Planning Application Ref: FG/150/17/T

Location: 3 Glen Gardens, Ferring

Description of works: Reduce and reshape the longer leaders by 4m overall and crown lift to 5m above ground

3 Glen Gardens Ferring

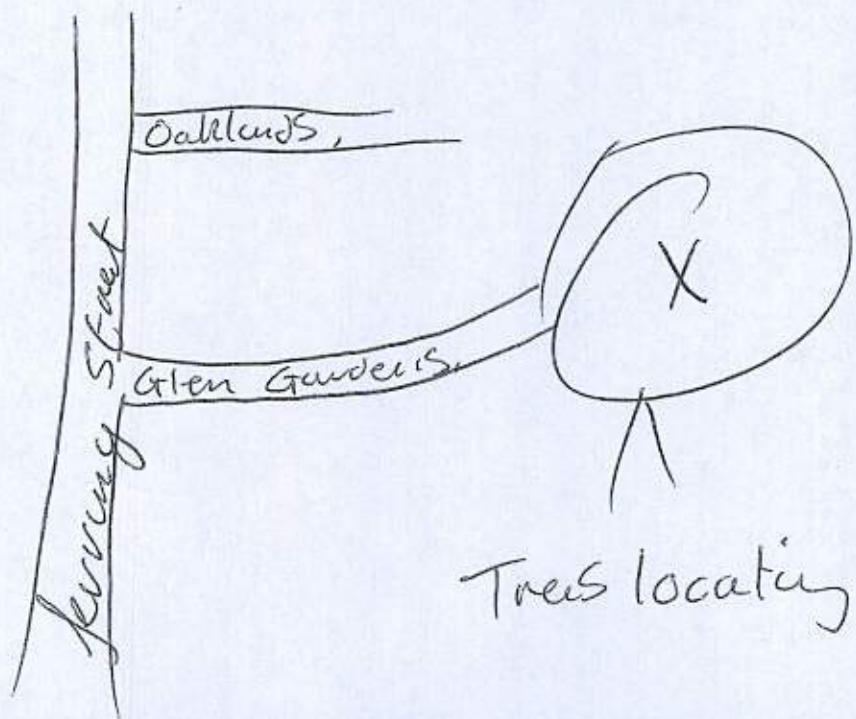
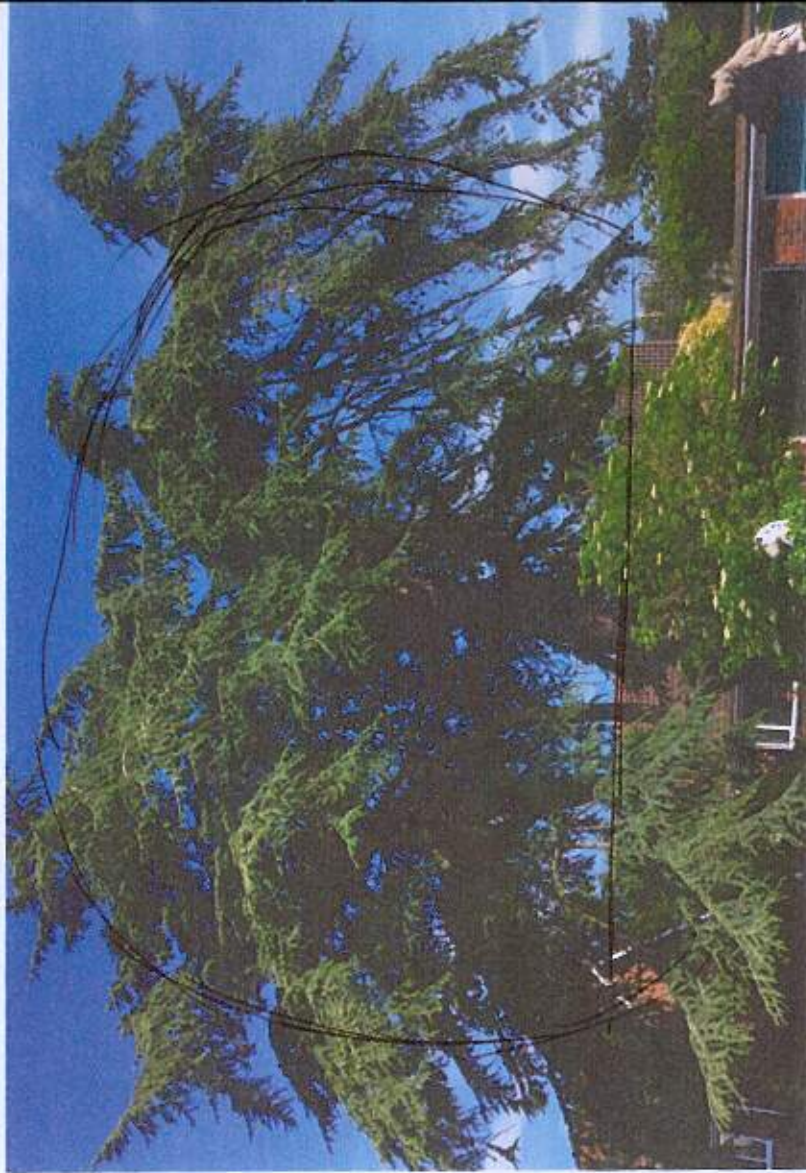
- Sound and healthy and showing good vigour and vitality – highly visible in the landscape and of high amenity value.
- Has an open straggly habit to the upper crown zone and a very low branching habit over the house and drive.
- Shortening back the longer leaders by up to 4m will bring the crown back under control and give it a more compact form.
- Crown lifting to 5m will give good ground clearance over the driveway and house - as it currently grows down to within 2m of the ground.

- The works proposed are reasonable and will negate the problems without adversely impacting on health and vitality or visual amenity value.

- I recommend **APPROVAL** for the works as listed in the application and as shown on the annotated photographs - subject to the following :-

- Where branches are to be shortened back the final cuts are to be made at the correct angle shown in BS3998:2010 and adjacent to a live bud or lateral.
